Rezoning Transportation Analysis

Petition Number: 2020-083

General Location Identifier: Tax ID 12703702

Date	Description
07-23-20	First Review
09-23-20	Second Review
10-20-20	Third Review
12-28-20	Fourth Review

TECHNICAL DATA PLAN

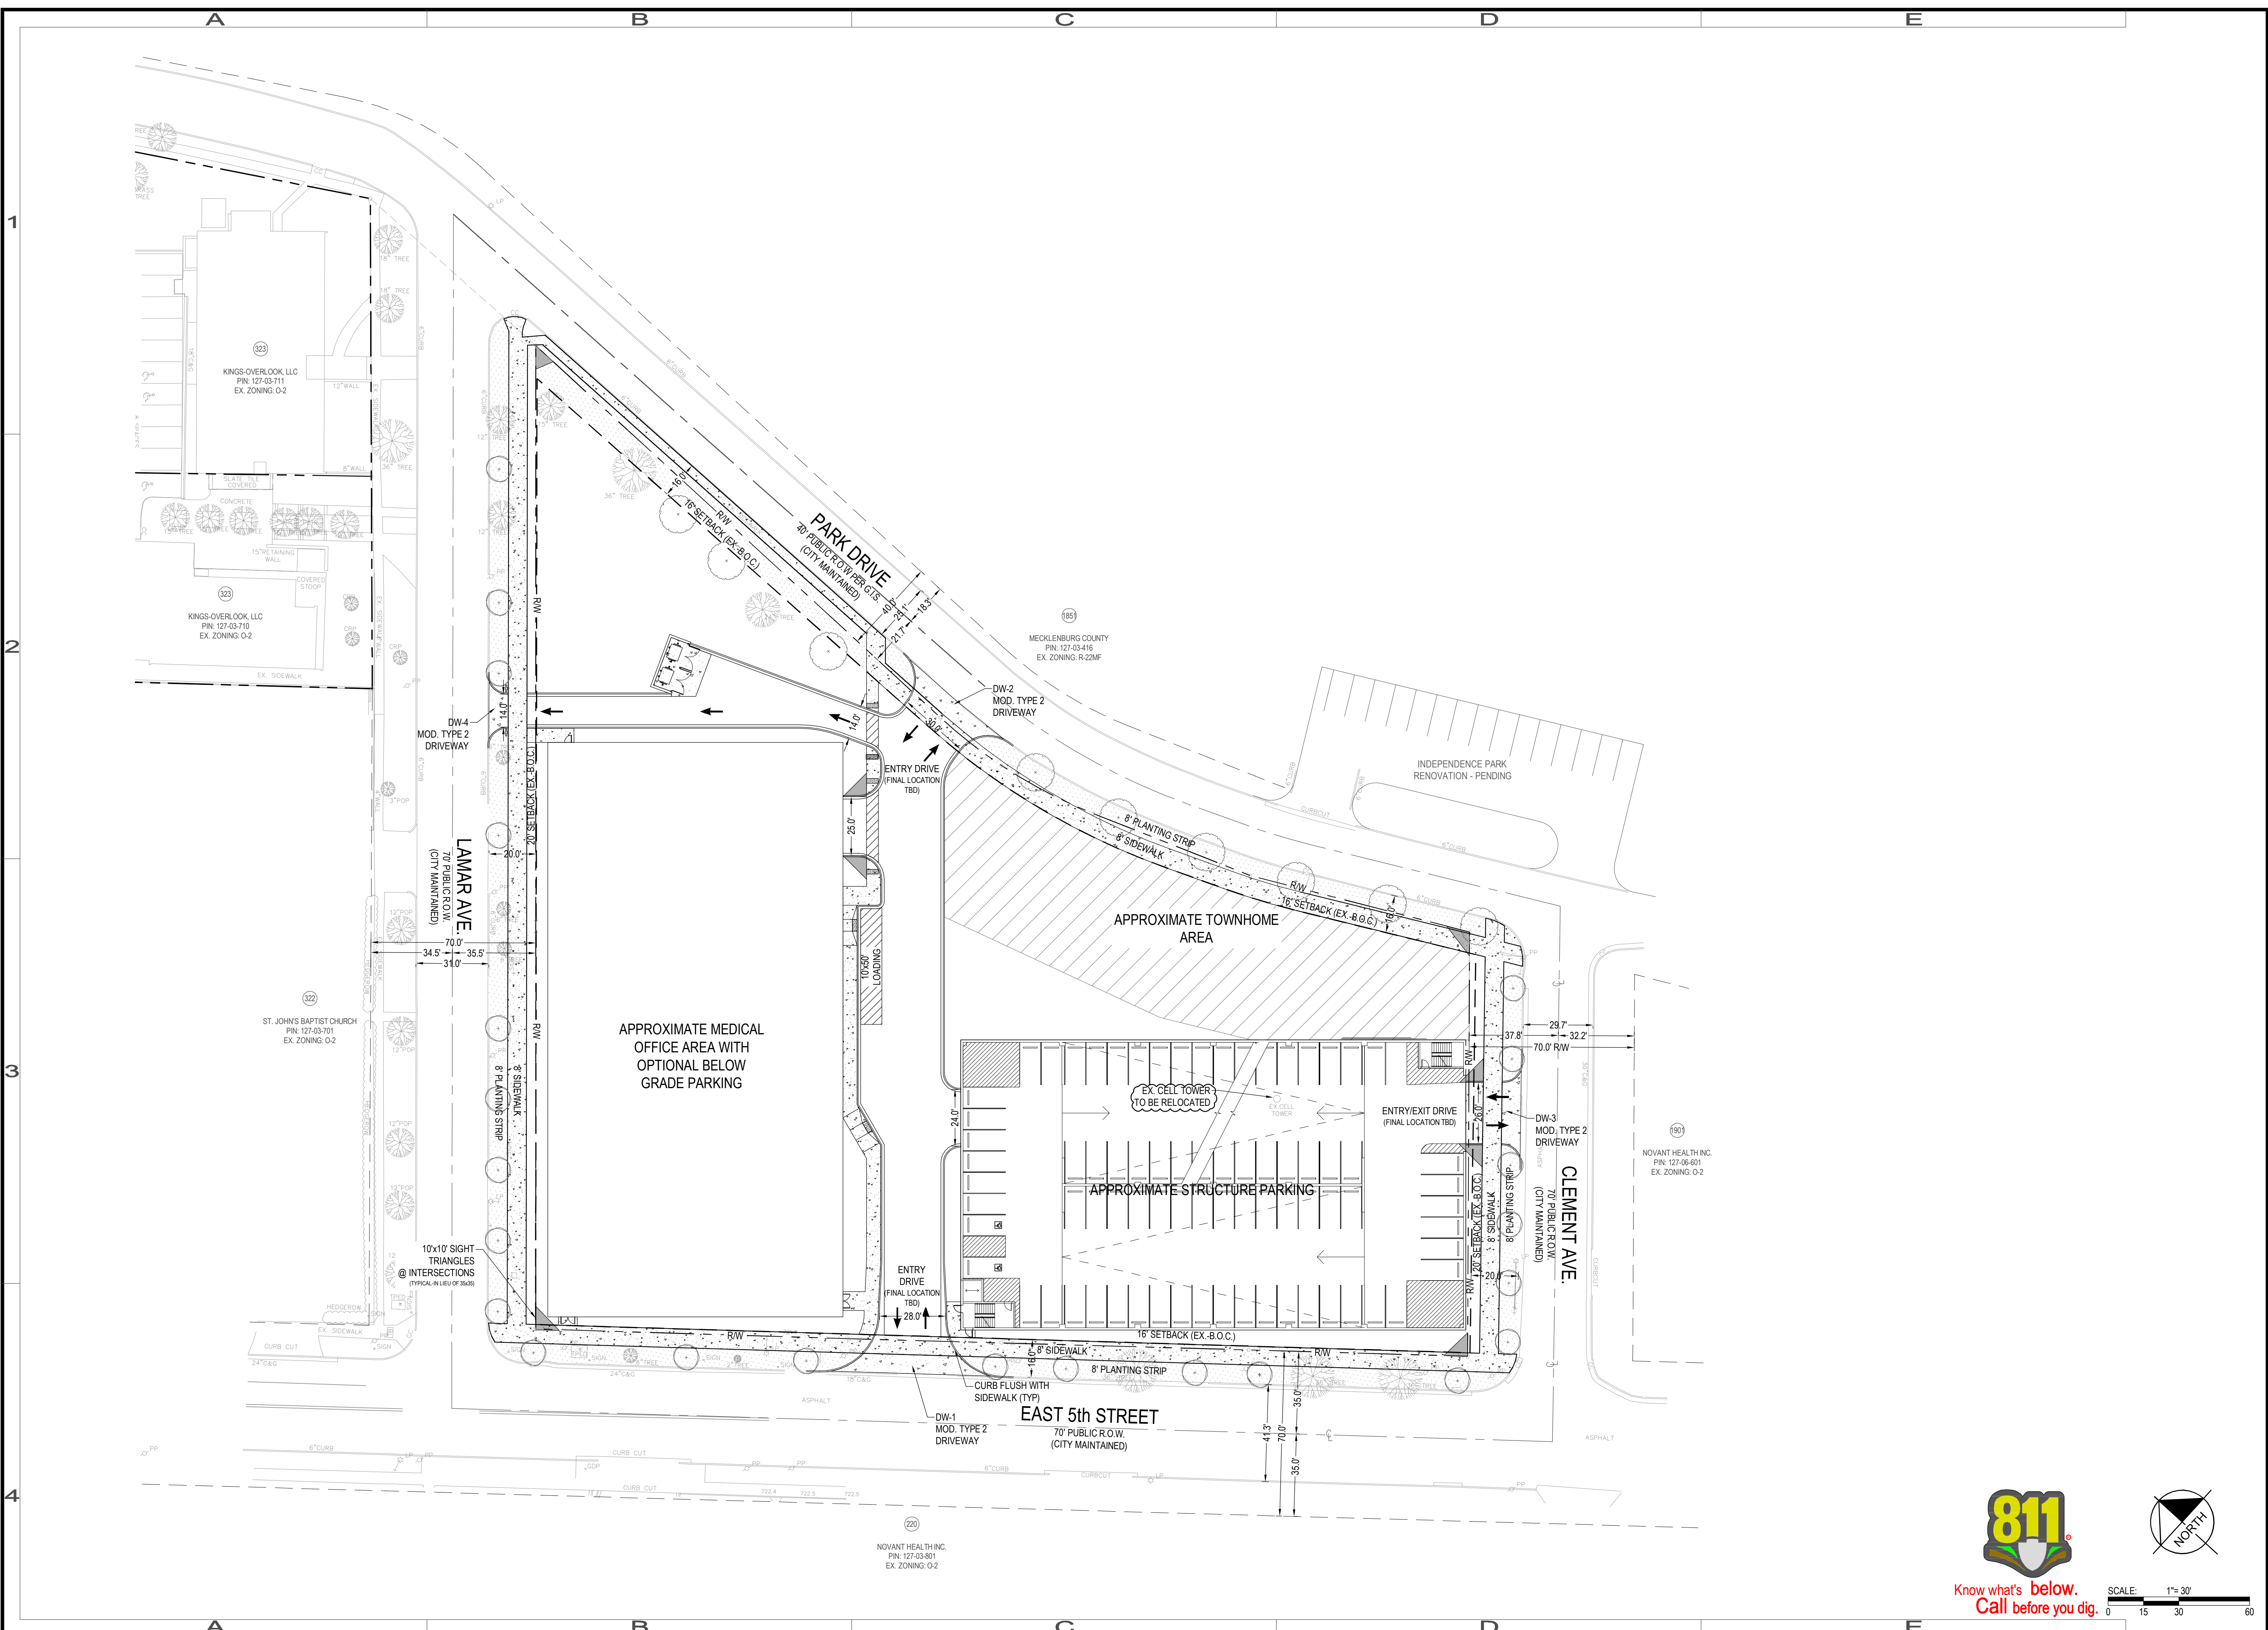
2. **Traffic Study** A Traffic Impact Study is necessary for the complete review of this petition due to the site generation of more than 2,500 daily trips.

Staff will receive the petition and review it, but the public hearing will not be scheduled until the TIS is received. This will allow for the minimum time necessary for CDOT to review and approve the study and reach agreement with the petitioner on the required transportation commitments, and have them included on the last site plan submitted no fewer than 4 weeks prior to the public hearing. Therefore, additional traffic mitigation comments may be forthcoming once the TIS is approved by CDOT and NCDOT.
